The Parish Councils of Assington, Bures St Mary, Leavenheath, Little Cornard, Polstead & Stoke by Nayland

Further written comments on Cable Sealing End Compounds following Bramford-Twinstead (EN020002) Issue Specific Hearing 4

STOUR VALLEY EAST  
 CABLE SEALING END  
 COMPOUND AT LITTLE  
 CORNARD

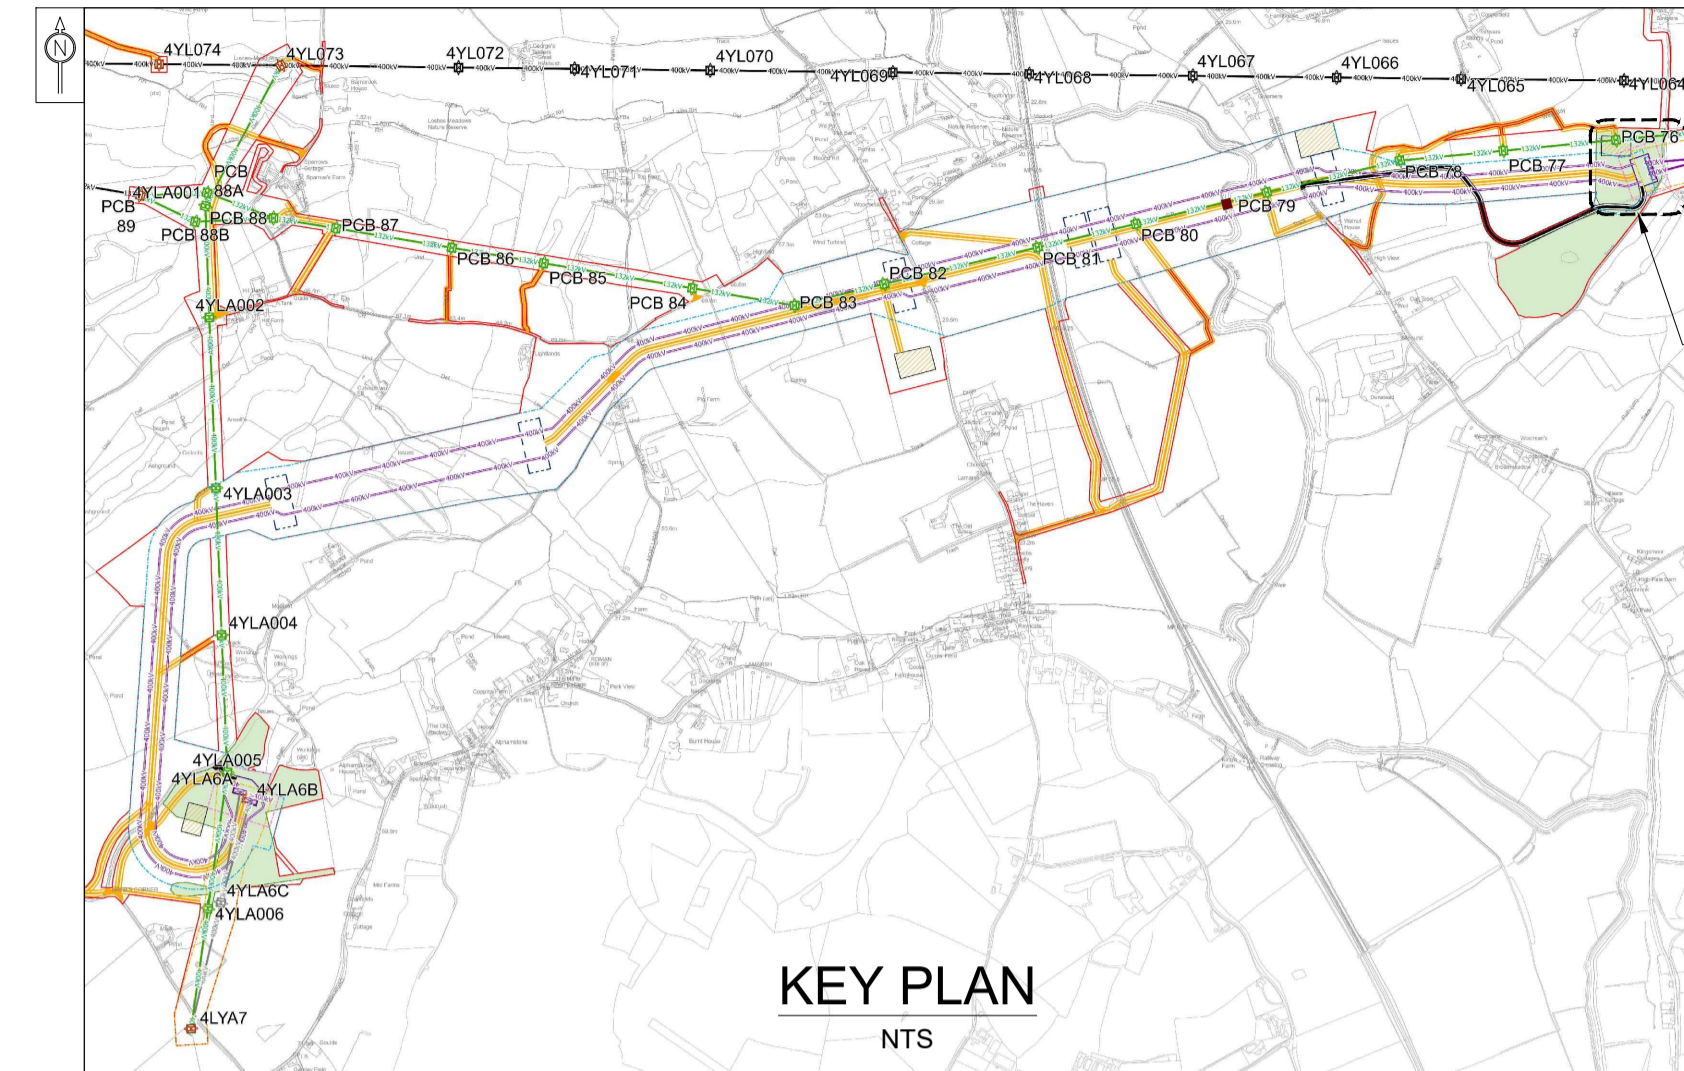
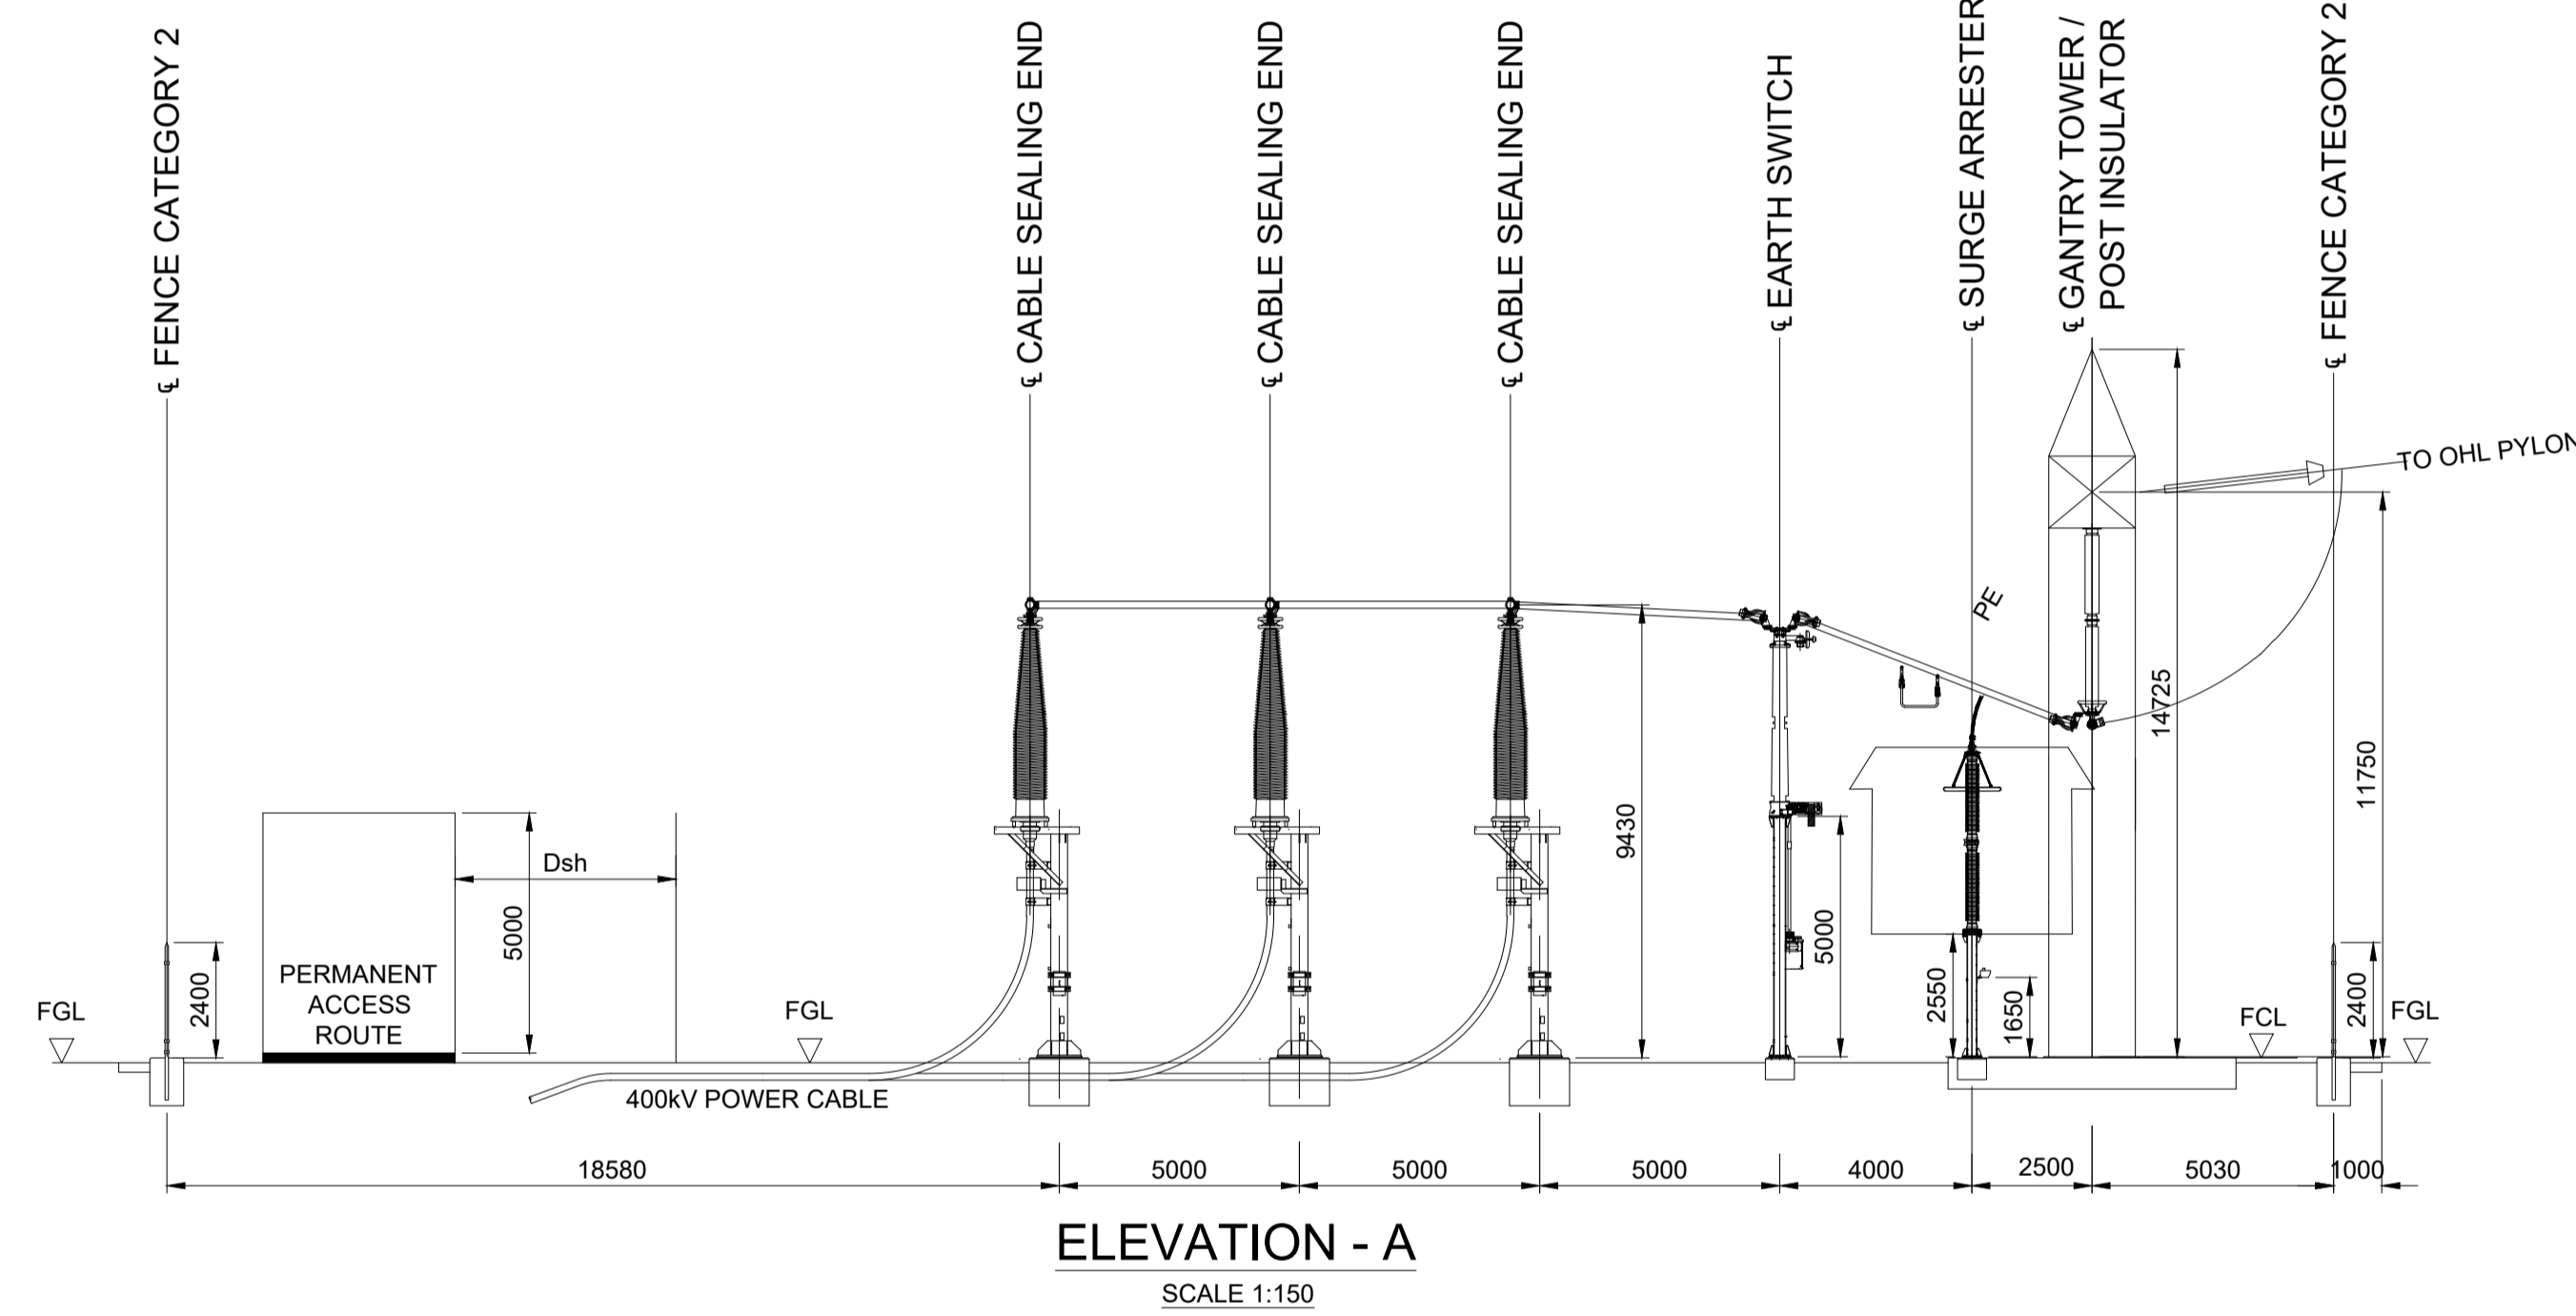
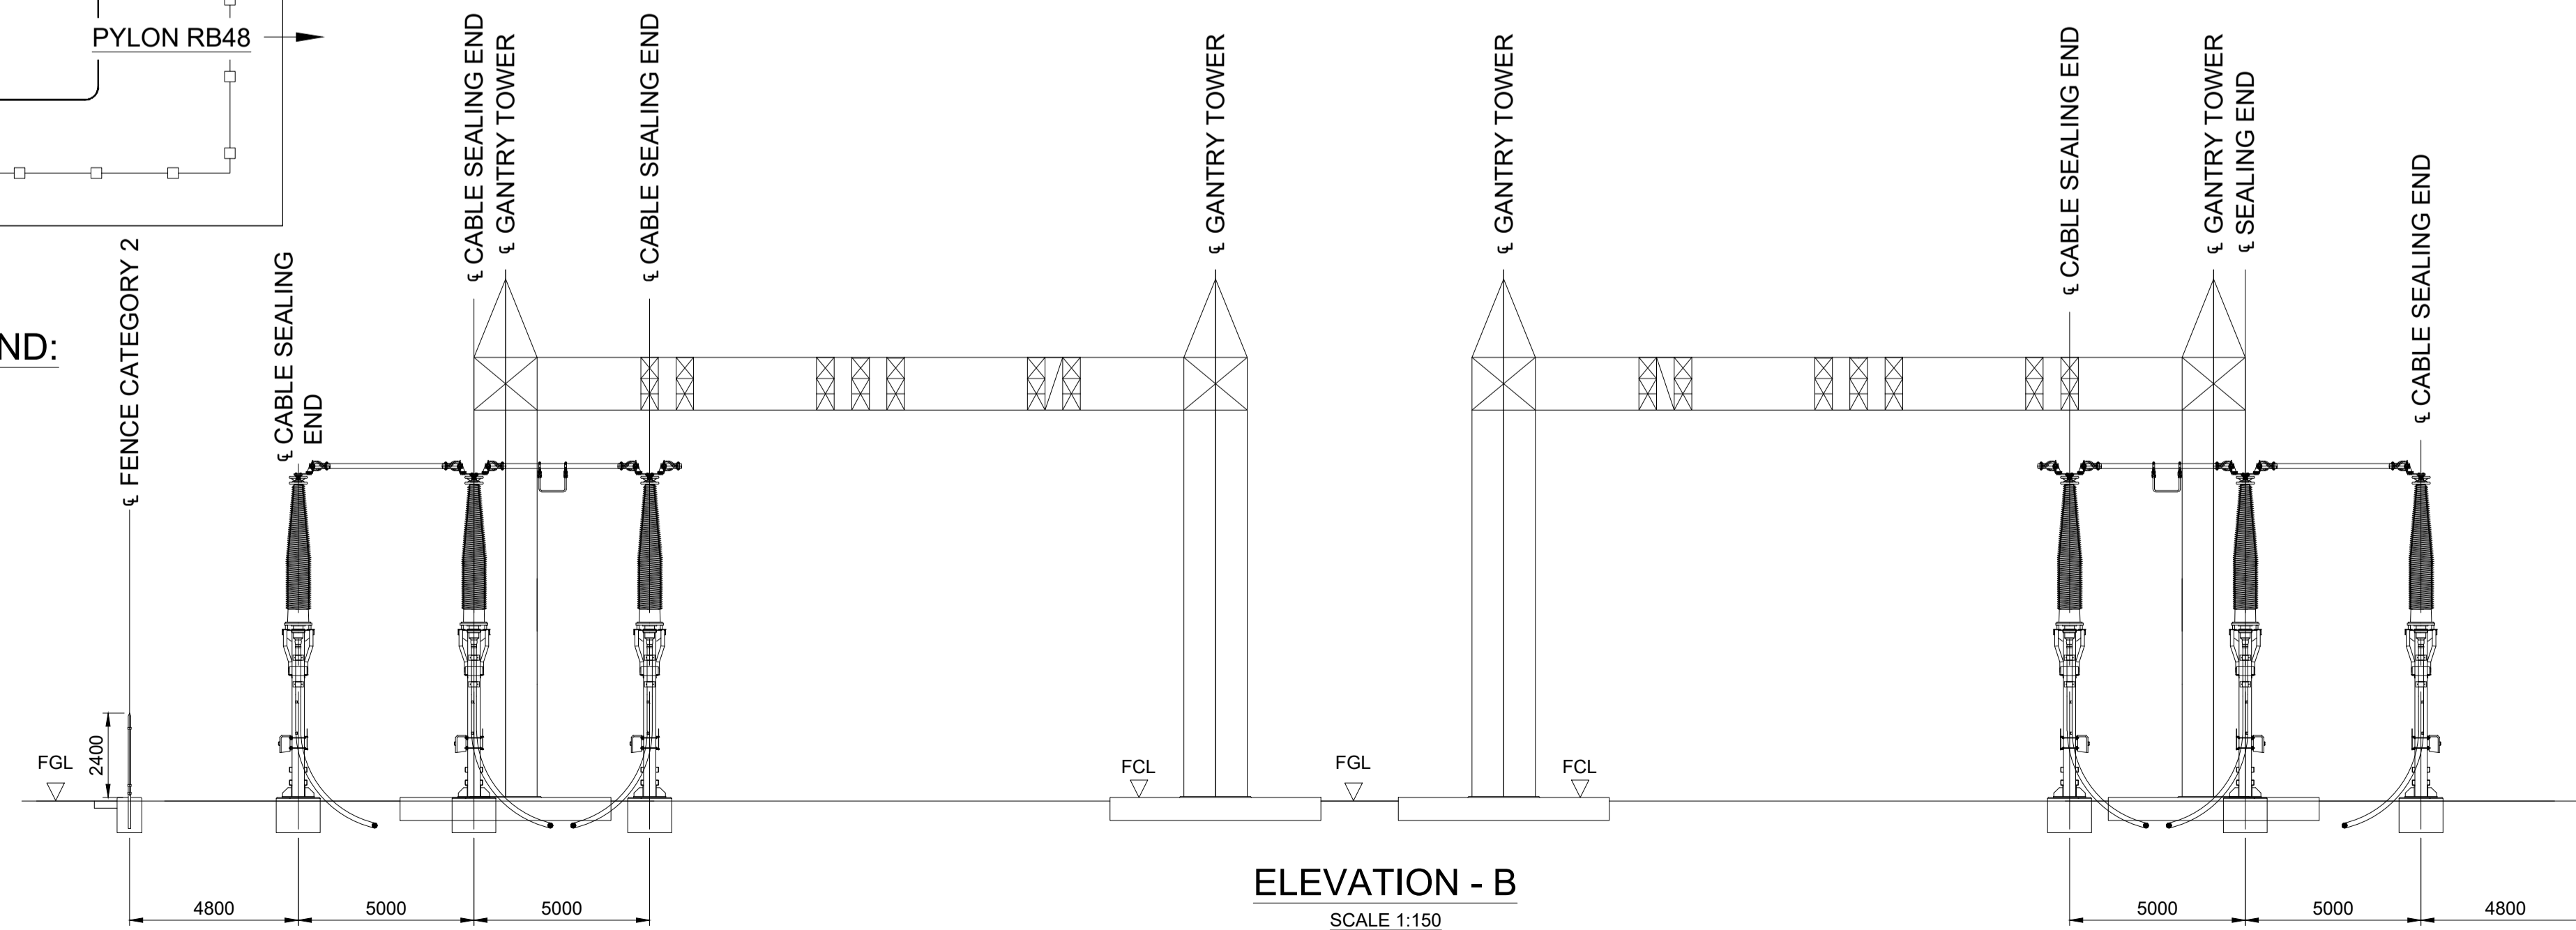
- 2.1 During ISH4 we referred to the high level of visual impact from the proposed permanent access road to the CSEC as proposed in APP-018 sheets 19 & 20. Our concerns focus on the visibility of the road from the Daws Hall area (TL 88764 36643) as shown in Appendix 1.

- 2.3 The proposed permanent access road creates a new junction on the B1508 and crosses a currently completely undeveloped area, which is highly visible from the opposite side of the Stour valley.

- 2.4 While we believe that the undergrounding of Section F could be comprehensively justified in order to reduce the proposed development's impact on both the Dedham Vale AONB and the Stour Valley Project Area, in the event that undergrounding is not pursued, we propose an alternative route for the CSEC access (locations mapped in Appendix 2): using an existing junction to the south of the one proposed at TL 89910 36603, passing two houses then using existing track all the way. The access is serviceable in terms of splay onto the B1508.

- 2.5 In our view, this alternative is preferable for three key reasons:
 - 2.5.1 Visual impact is greatly reduced: the track already exists, and is well hidden by mature hedge and trees from the other side of the valley. Views from the Little Cornard area of the B1508 and Spout Lane would be less impacted than by a new road through a field, and the need for a new junction with the B1508 would be removed.

- 2.5.2 Upgrading the existing track to a permanent road would improve access for all to the area including the houses it passes and for agricultural vehicles, providing a community benefit. Adding hedging to screen the access from the B1508 would further reduce the impact

- 2.5.3 Disruption and excavation of an area close to an existing and occupied badger sett (near PCB 78) would also be reduced.
- 2.6 The current impact of the SVEast CSEC access road is significant in our view, and we appeal to the ExA and the applicant to give our proposals careful consideration.
